From: Martyn White
Sent: 24 June 2019 12:22
To: Planning.Responses
Cc: Anita Gardner
Subject: AB/48/19/PL & AB/49/19/L

AB/48/19/PL & AB/49/19/L

Listed building consent for internal and external alterations to facilitate the change of use of upper floors to a single, four bedroomed residential unit [use class C3a] and ground floor to a commercial unit (use classes A1,A2 & B1a).

terrier firma

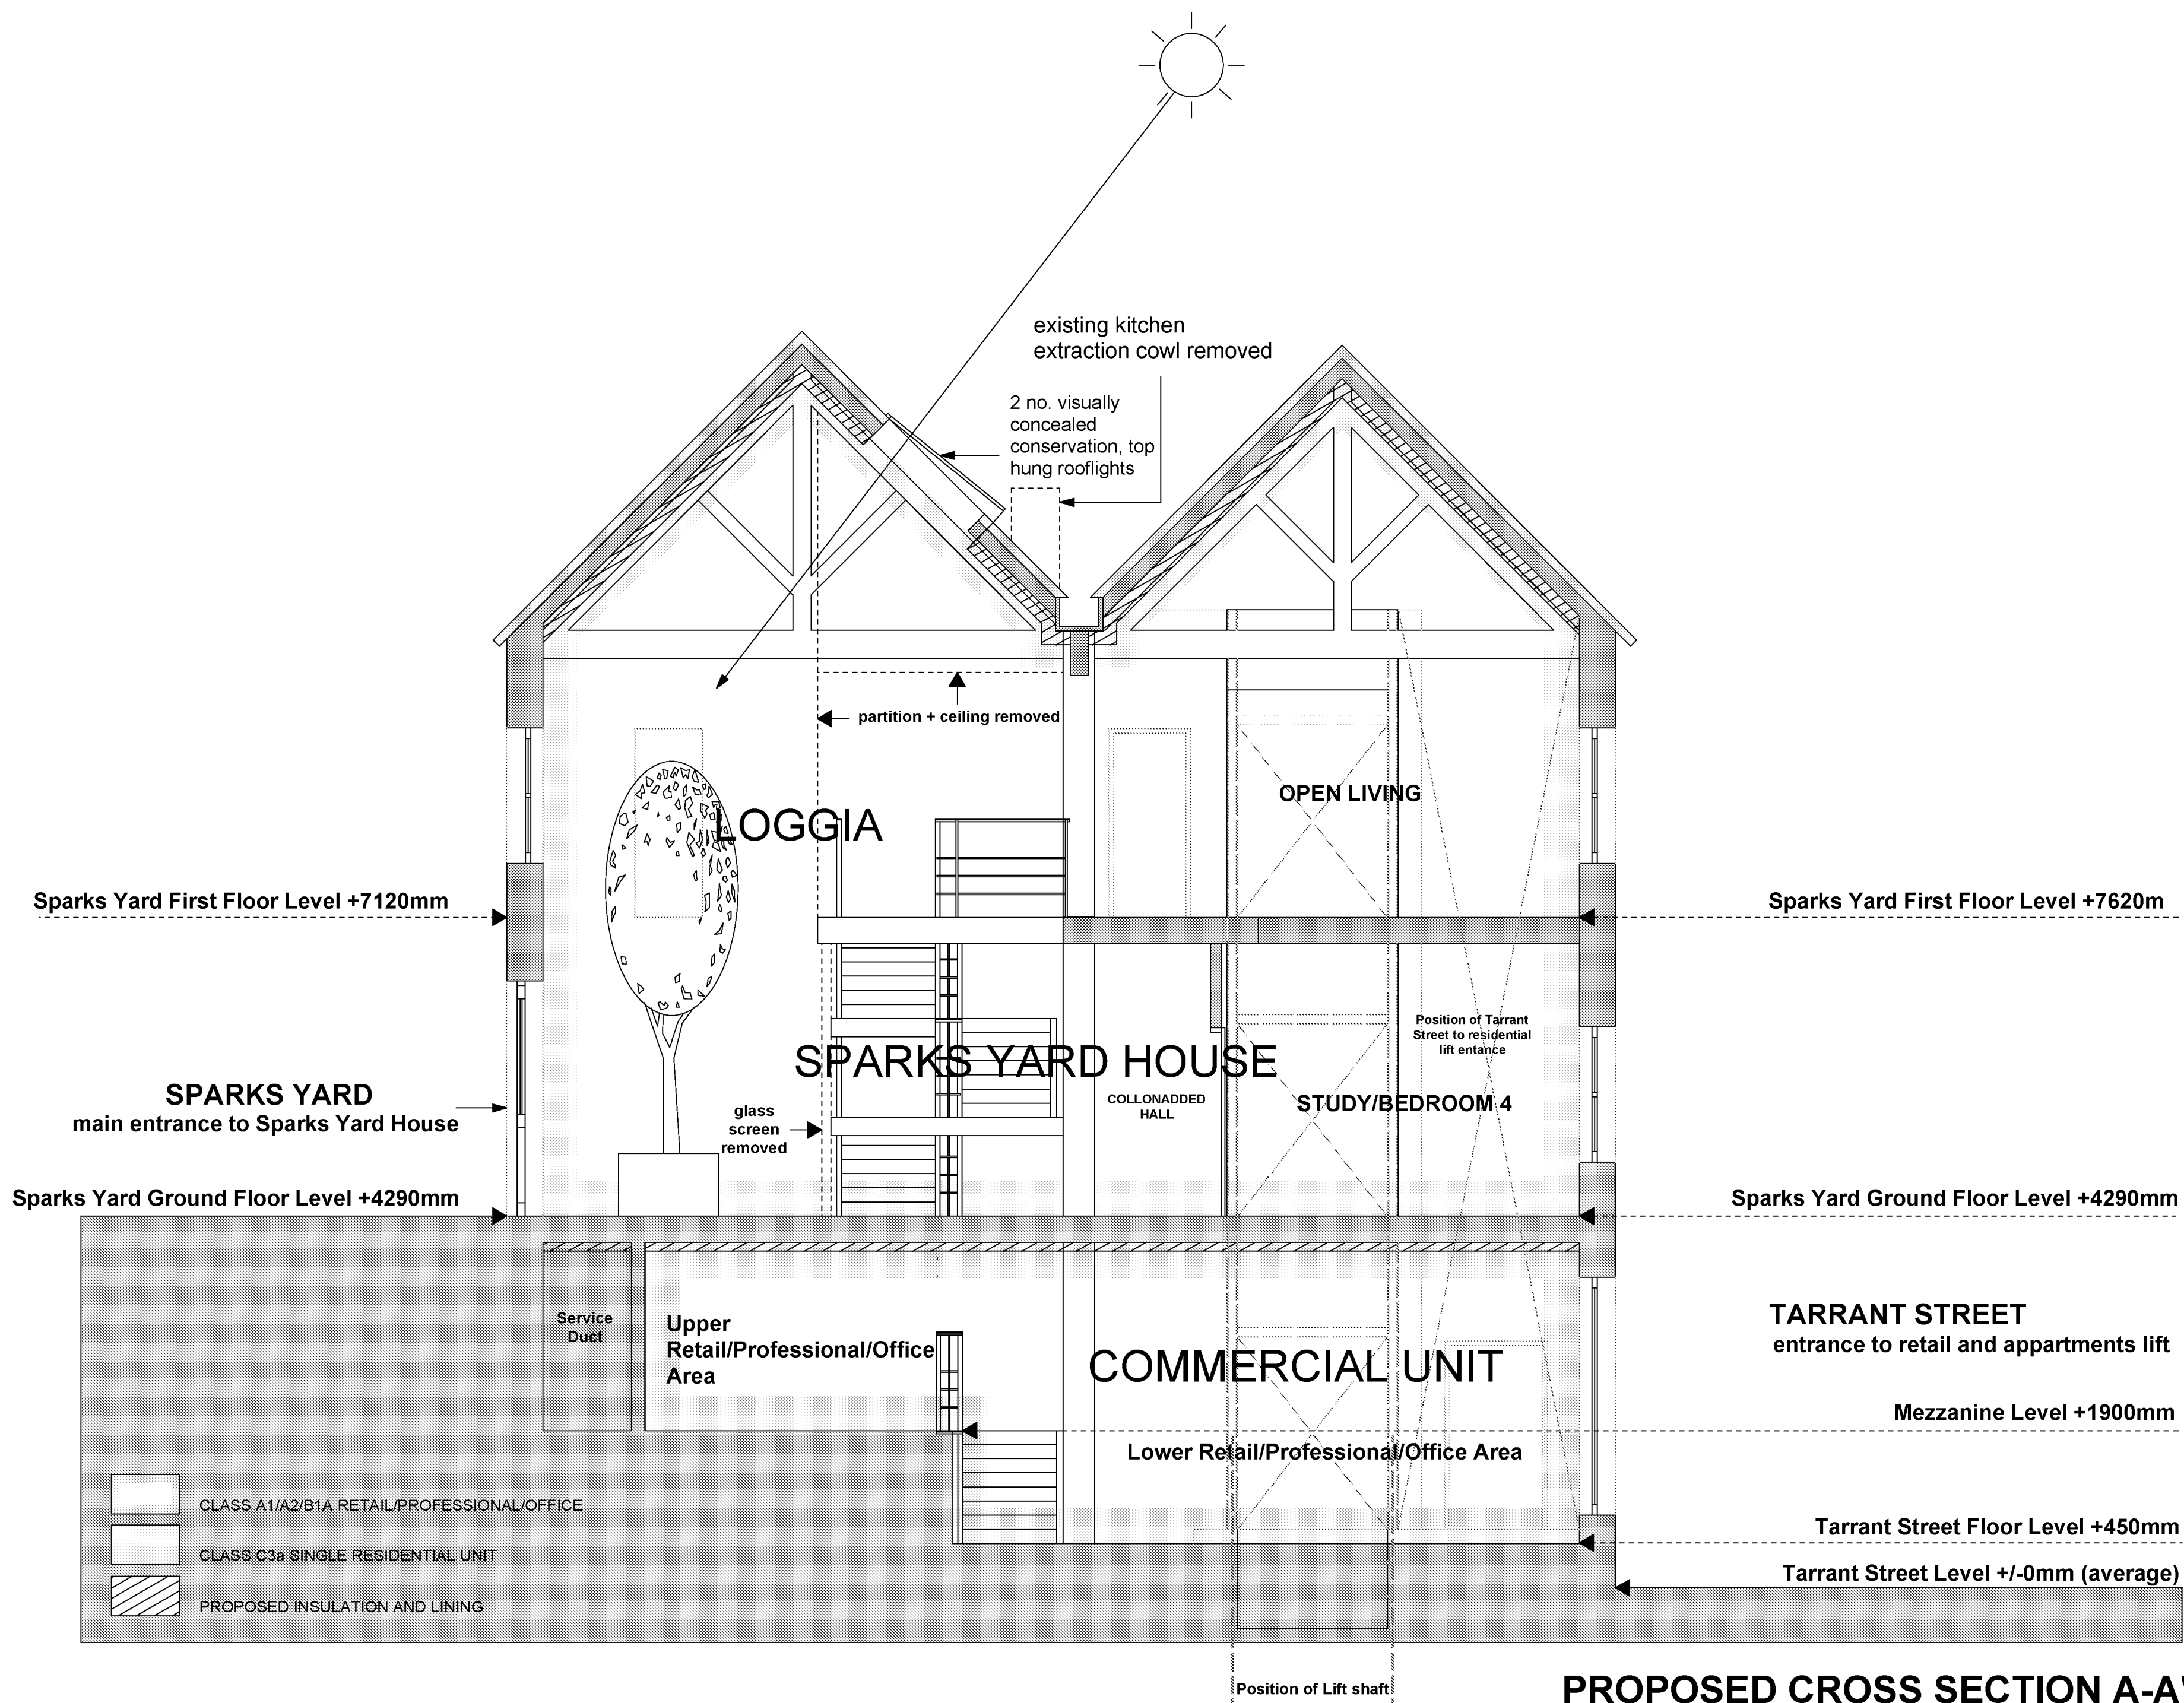
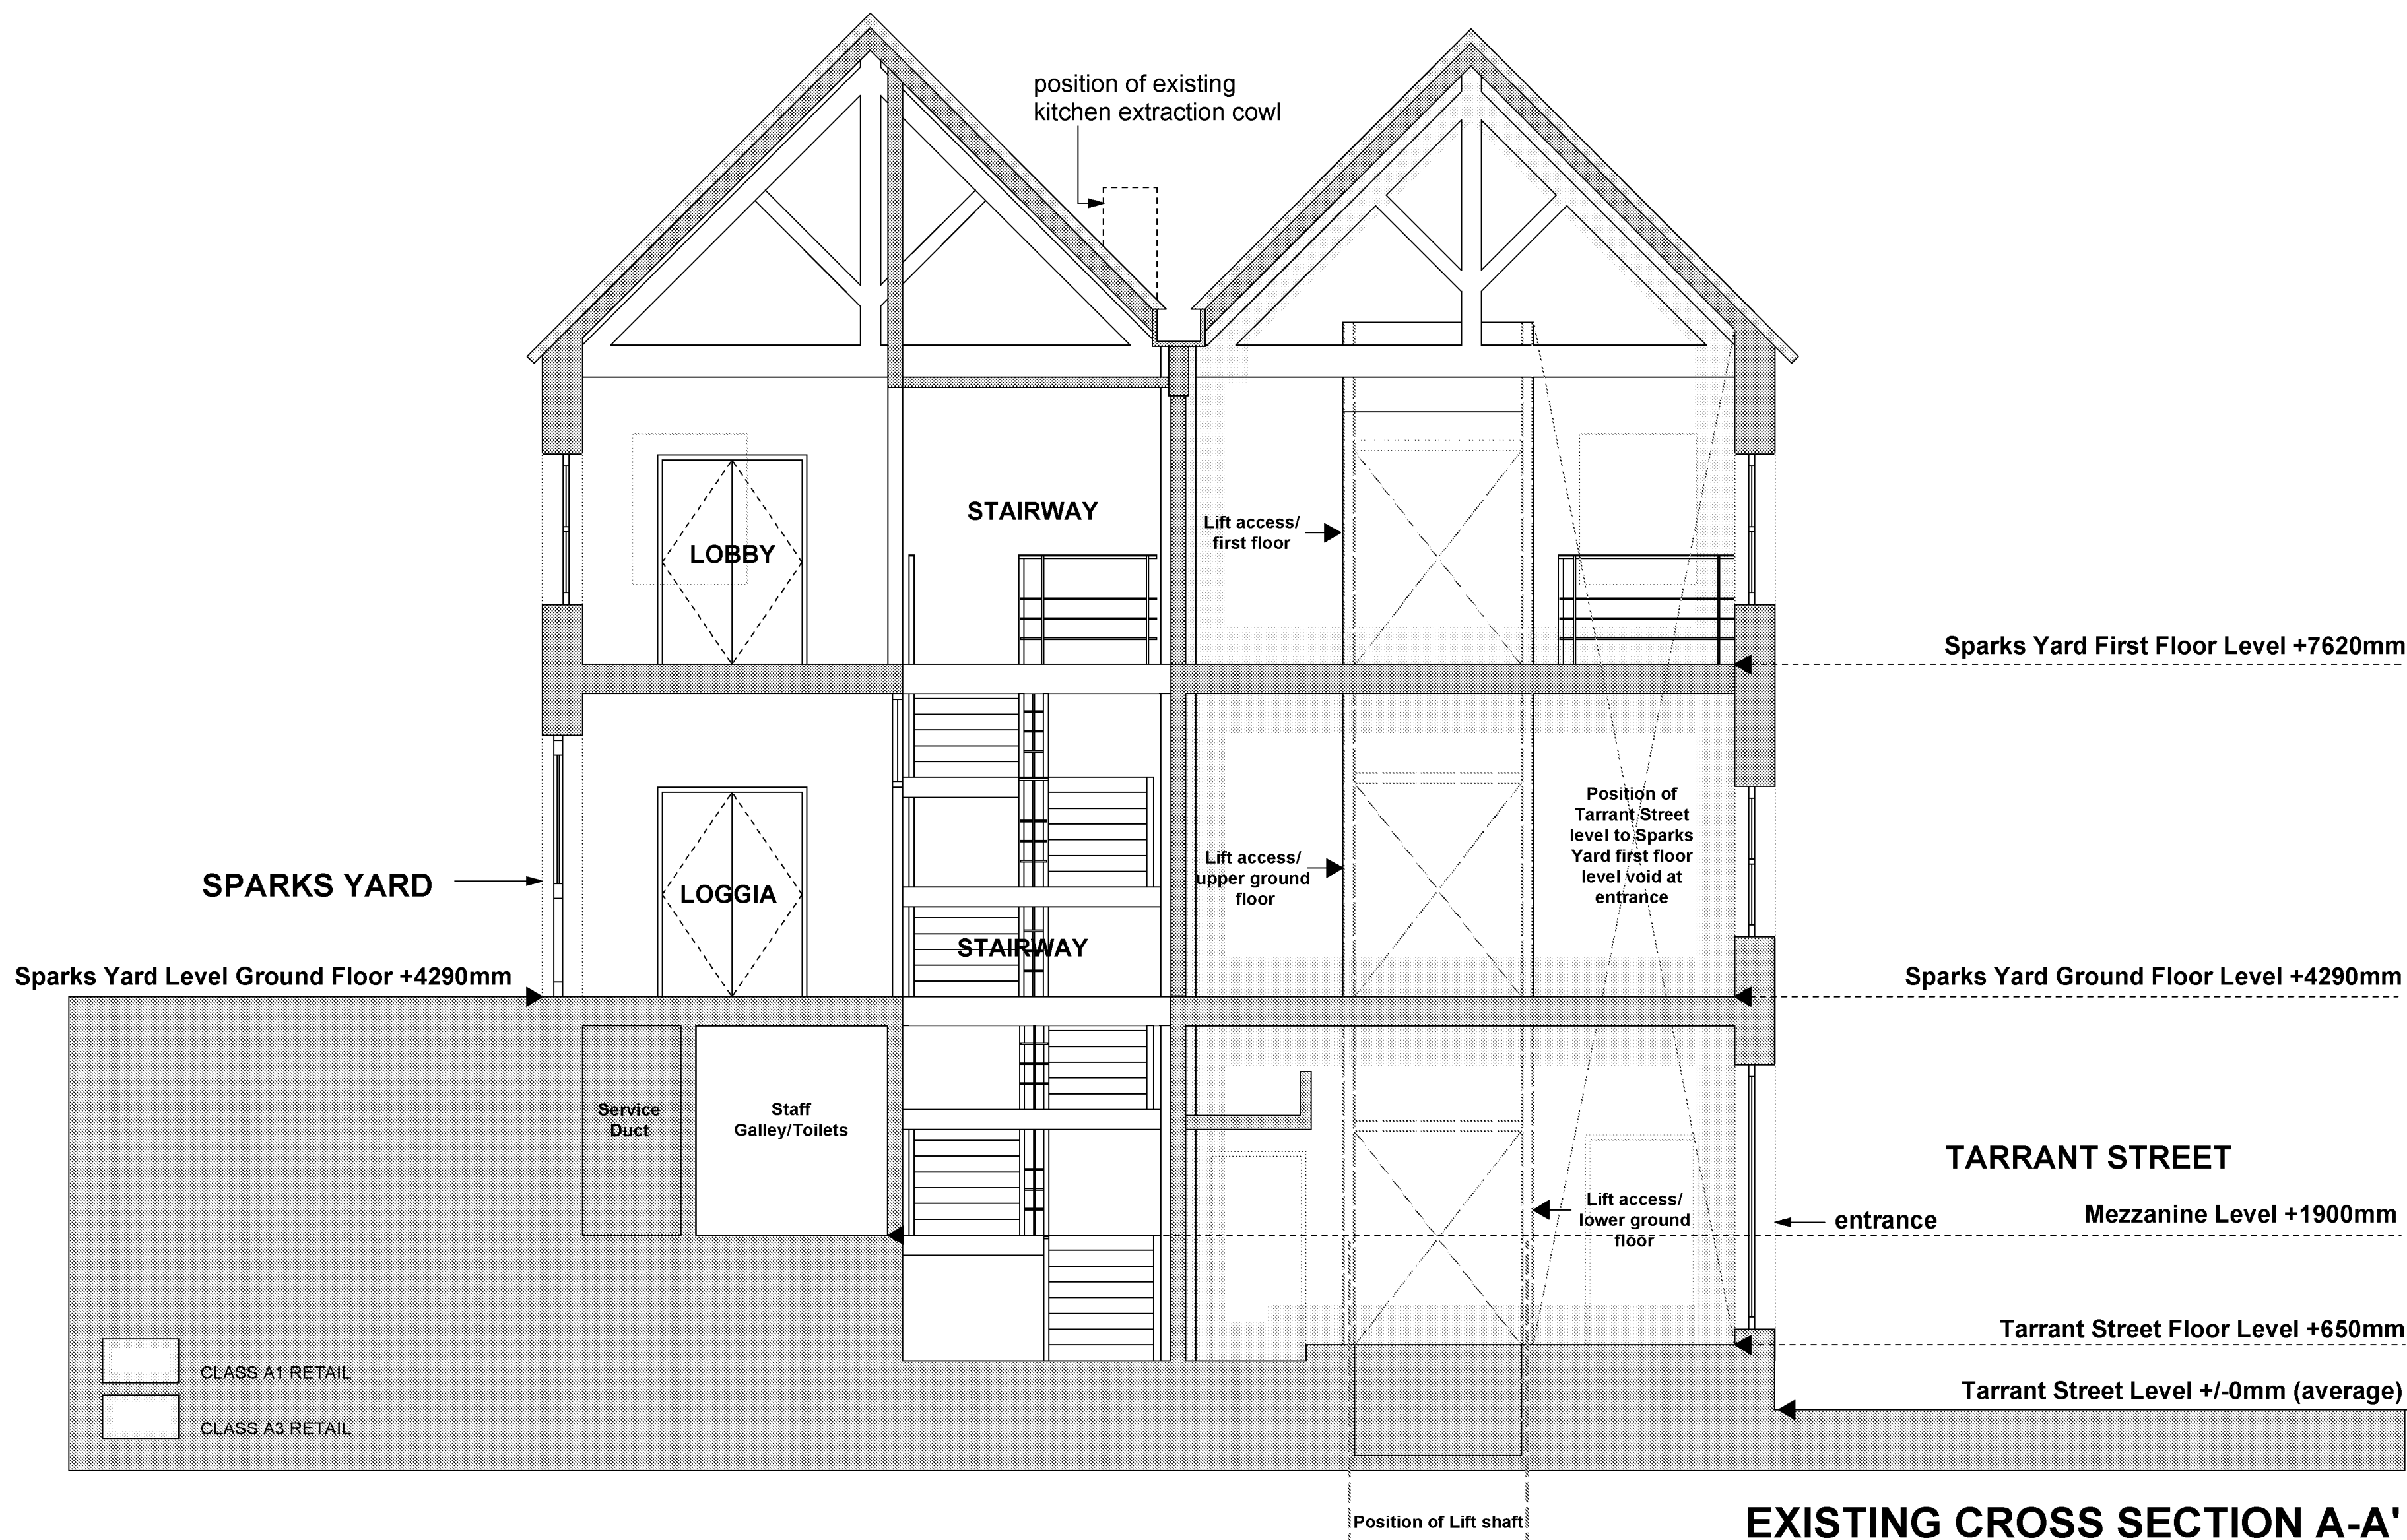
The only concern relates to the proposal to cover internal brick walling with plasterboard. I note that reference is made to the fact that the brick walling will be left exposed if possible. However, covering up a significant amount of the brick work will negatively affect the character of the building. Such an issue should be reconsidered.
